**State Environmental Planning Policy (Infrastructure) 2007
State Significant Development Application – SSD-10473
270 Miller Street, North Sydney
Request for additional information**

270 Miller Street, North Sydney (SSD-10473)

Job Name : SCS Marist North Shore
 Sketch Title:
 Footing Plan

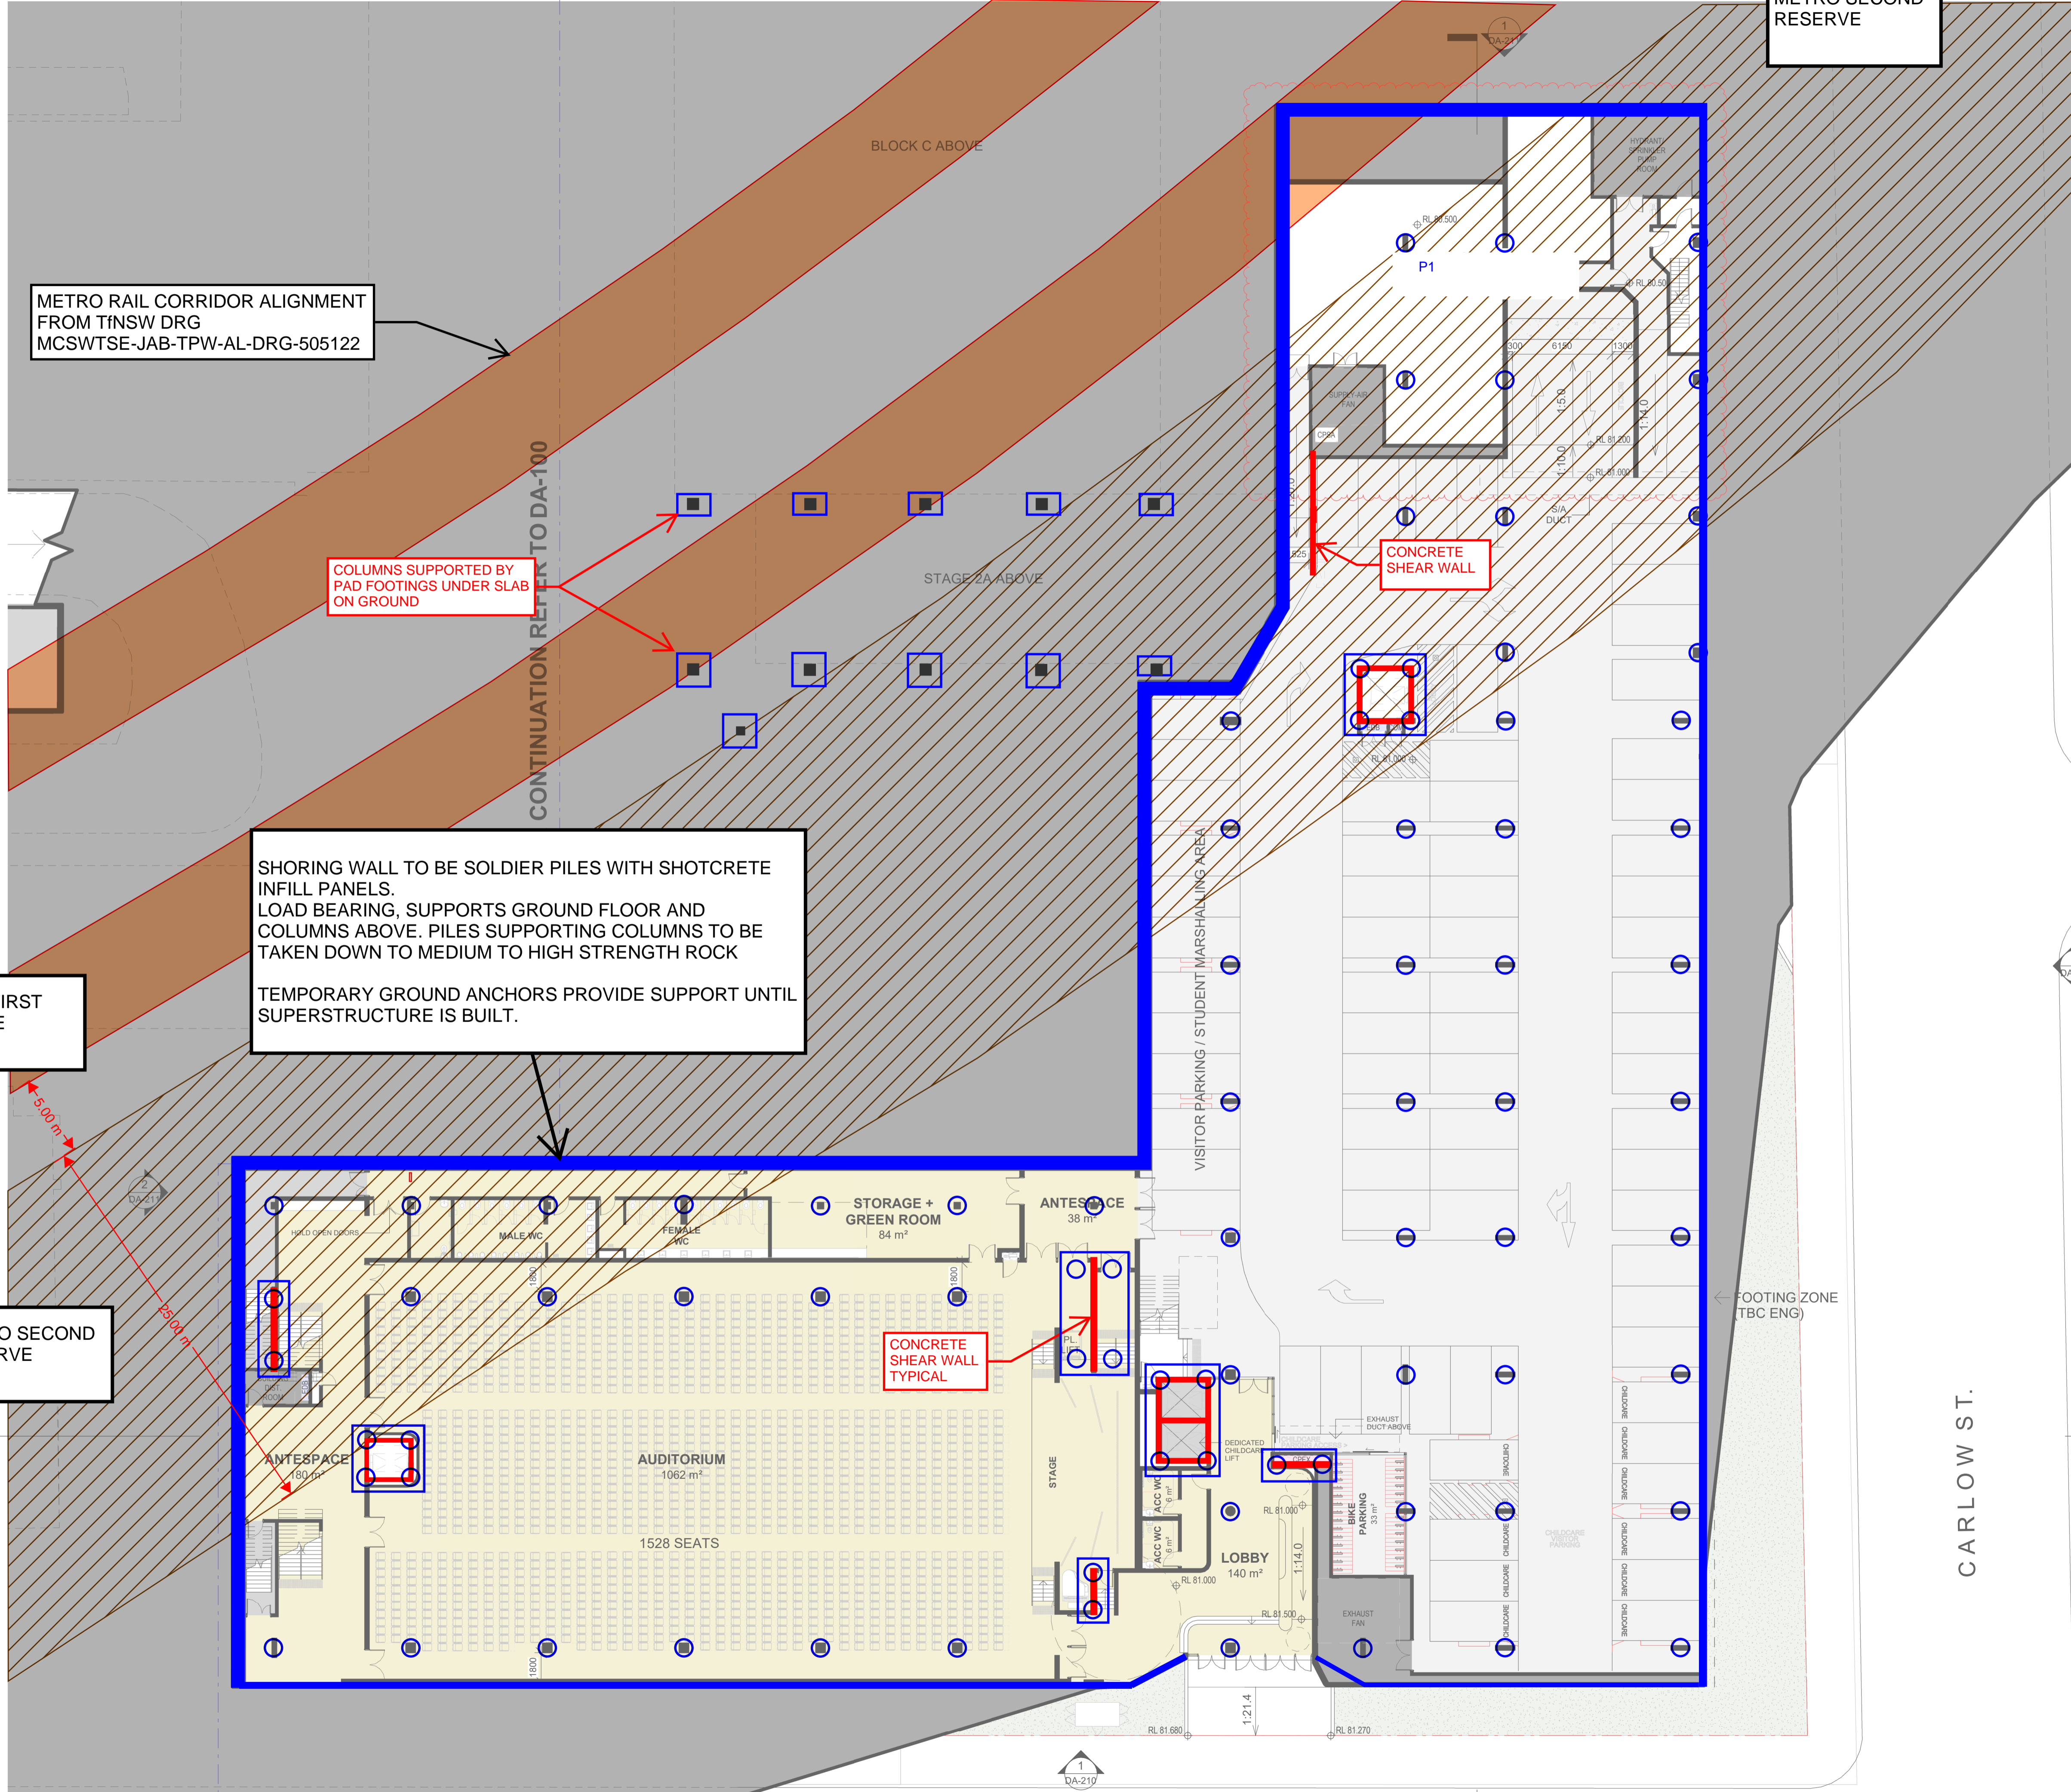
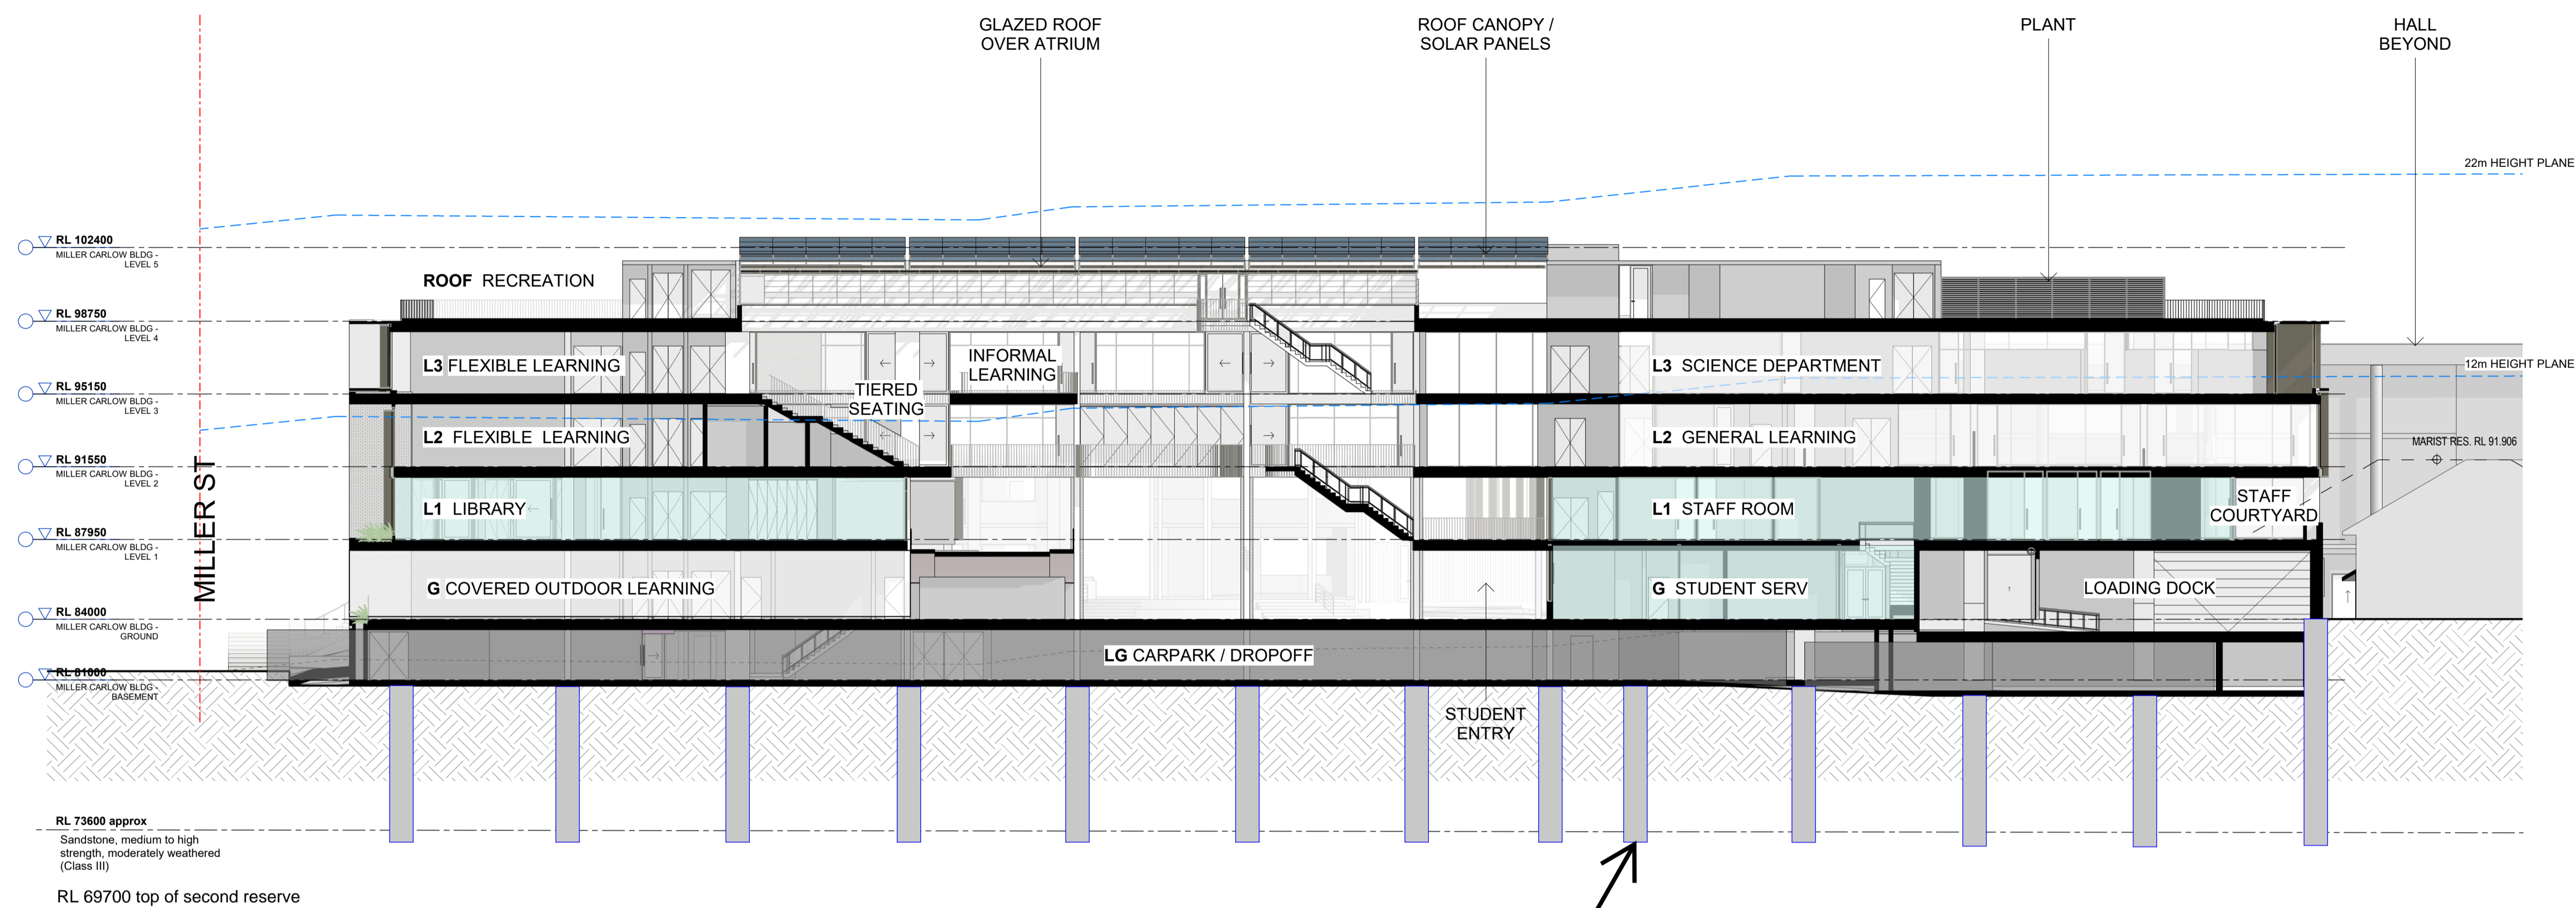
- a) The final design of pile foundation should be provided in order to confirm the risk levels on Sydney Metro infrastructure.
(together, Additional Information).
